SSD 6010 - One Residential Building (Student Accommodation) within Darling Drive Plot

Submission by:

DR WILBUR HUGHES

1ST August 2013

SHADOW DIAGRAMS: PERSPECTIVE, SHOWING THE PEAK, WINTER SOLSTICE

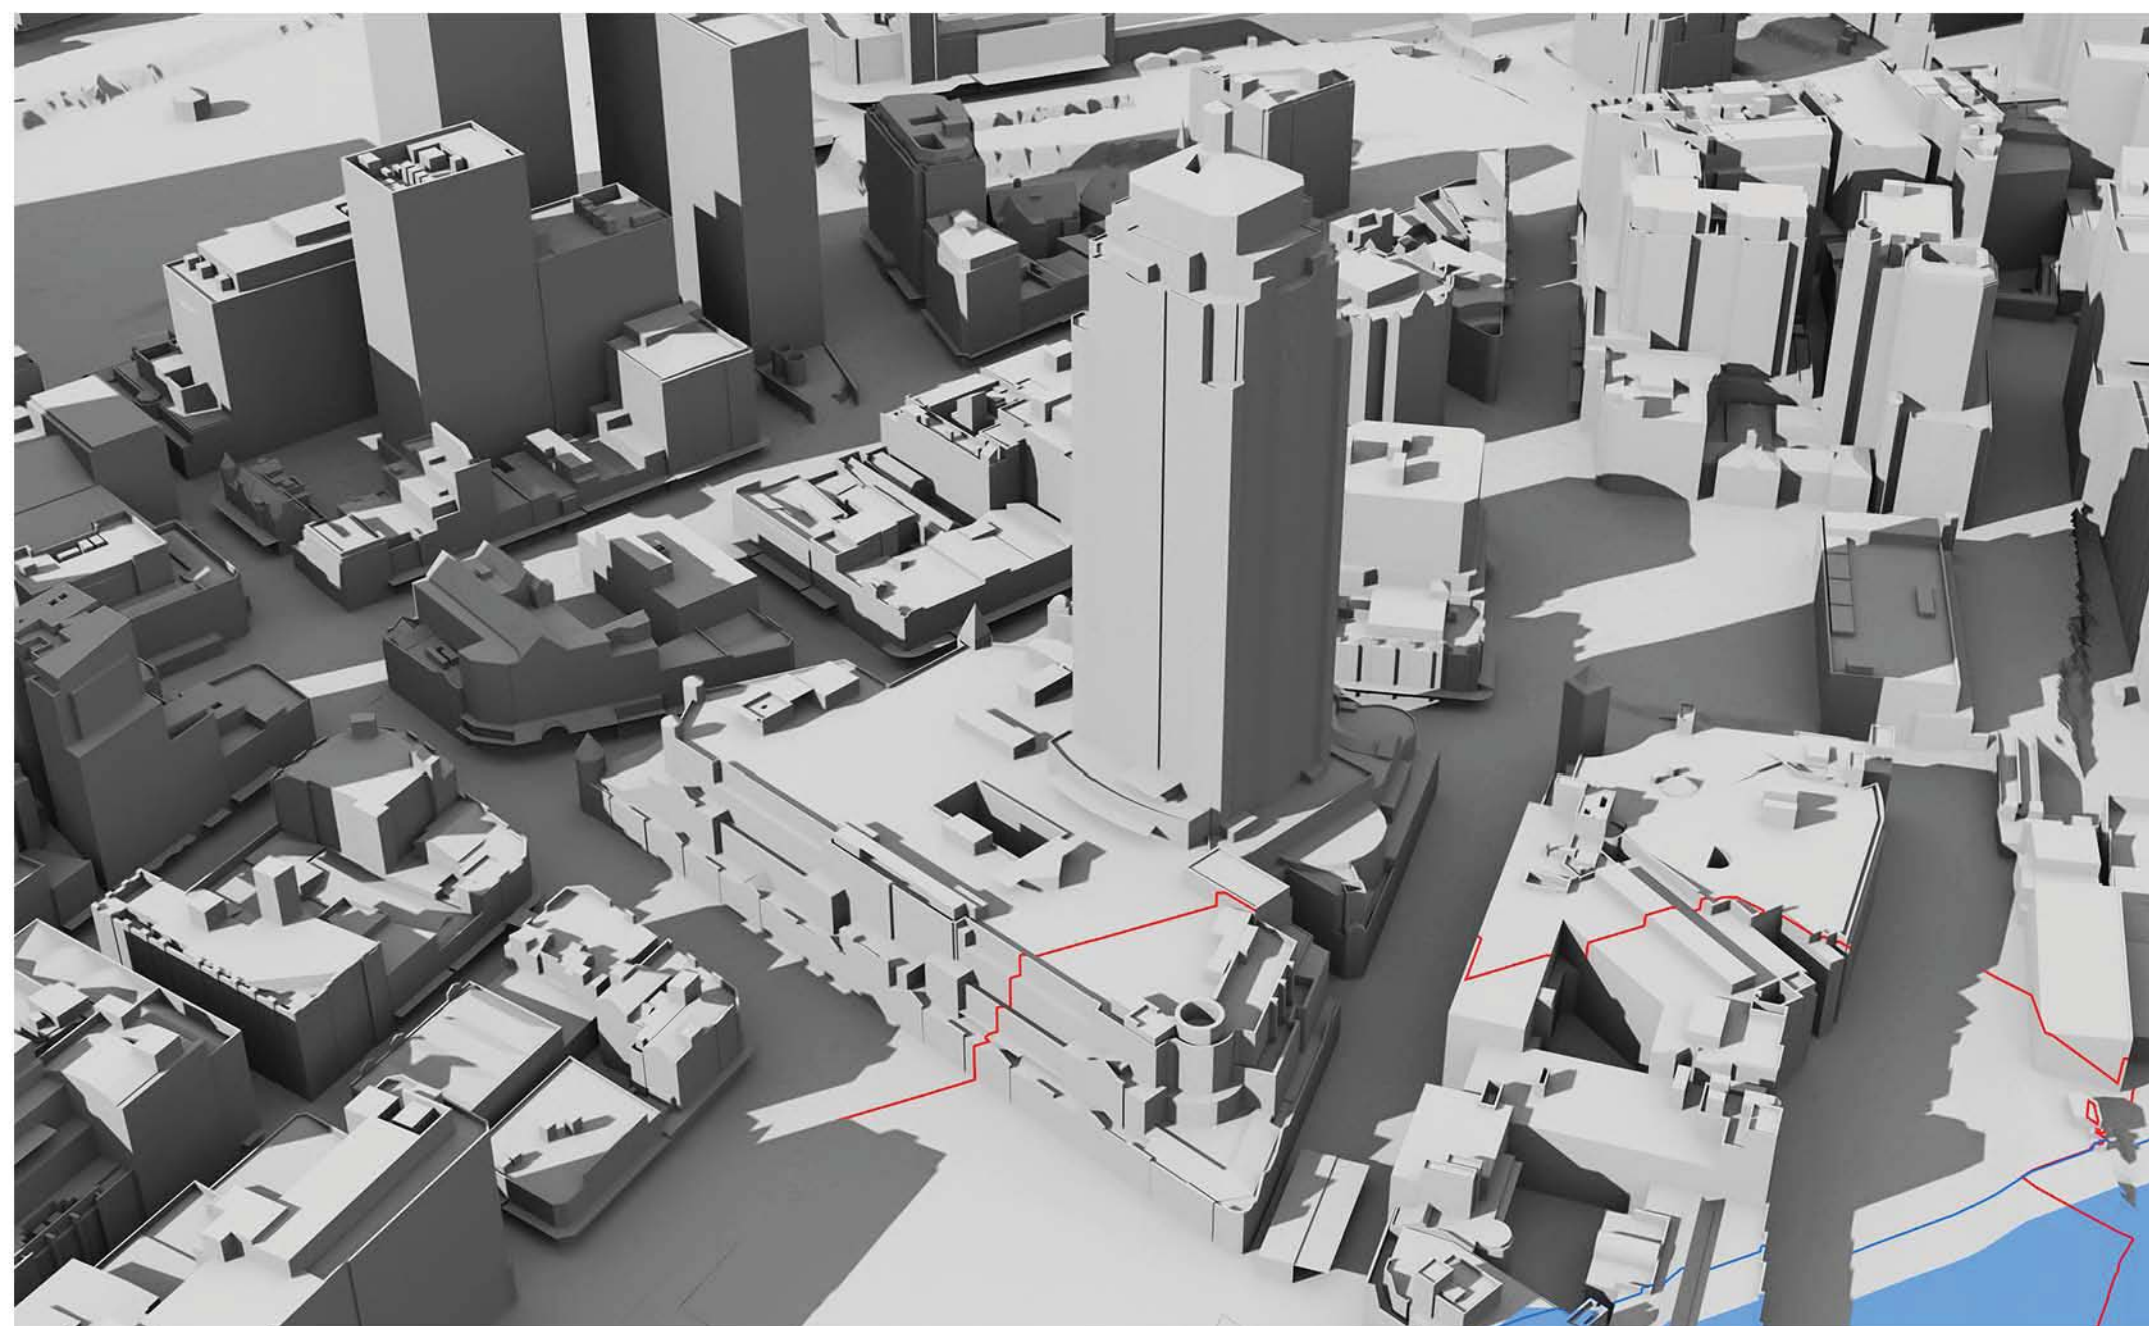
We refer to the shadow diagrams in SSD5878, Appendix H. Supplementary Design Report, Section 6. Amendments, Winter solstice - 22 June. This is not 21 June, but there would be no noticeable difference.

The south façade is not shown. On 21 June it would never receive any direct sunlight.

At 9am, 10am and 11am the west façade is totally in shadow due to other parts of The Peak building itself.

At 12pm there is still substantial existing shadowing on the west façade caused by the irregular shape of the west facade.

At 1pm the existing shadowing has been substantially removed, but not totally removed.

It can be concluded that some single aspect apartments on the west façade and some south-west dual aspect corner apartments currently receive less than 2 hours direct sunlight to habitable rooms and 50% of the private open space between 9am and 3pm on 21 June.

By 2pm the existing shadowing has been totally removed, but that is too late to achieve two hours of direct sunlight before 3pm.

At 9am, 10am and 11am the west façade is totally in shadow due to other parts of The Peak building itself.

At 12pm there is still substantial existing shadowing on the west façade caused by the irregular shape of the west facade.

At 1pm the existing shadowing has been substantially, although not entirely, removed. However, overshadowing of lower levels of the west façade by the concept proposal parameter plan shadows for the N,NE and SE plots has already started.

By 2pm the existing shadowing has been totally removed. However, overshadowing of the west façade by the SSDA4 and SSDA5 buildings has appeared and risen further up the west façade than the concept proposal parameter plan shadows for the N,NE and SE plots, which is still present.

At 3pm, the proponent states correctly that 45-45% of the western façade is overshadowed by the SSDA4 and SSDA5 buildings.

It can be concluded that, as a result of combination of the proposed development with existing shadowing of the west façade, some single aspect apartments on the west façade and the south-west dual aspect corner apartments which currently receive less than 2 hours direct sunlight to habitable rooms and 50% of the private open space between 9am and 3pm on 21 June will suffer additional overshadowing. It is beyond our skills to count the number of such apartments. We note that the proponent has made no attempt to do so.

Rather than counting the number of units which will not meet the DCP guidelines, the proponent attempts to trade-off direct sunlight at 4pm for lack of direct sunlight during the period 9am to 3pm. There is no provision in the DCP guidelines for such a trade-off.
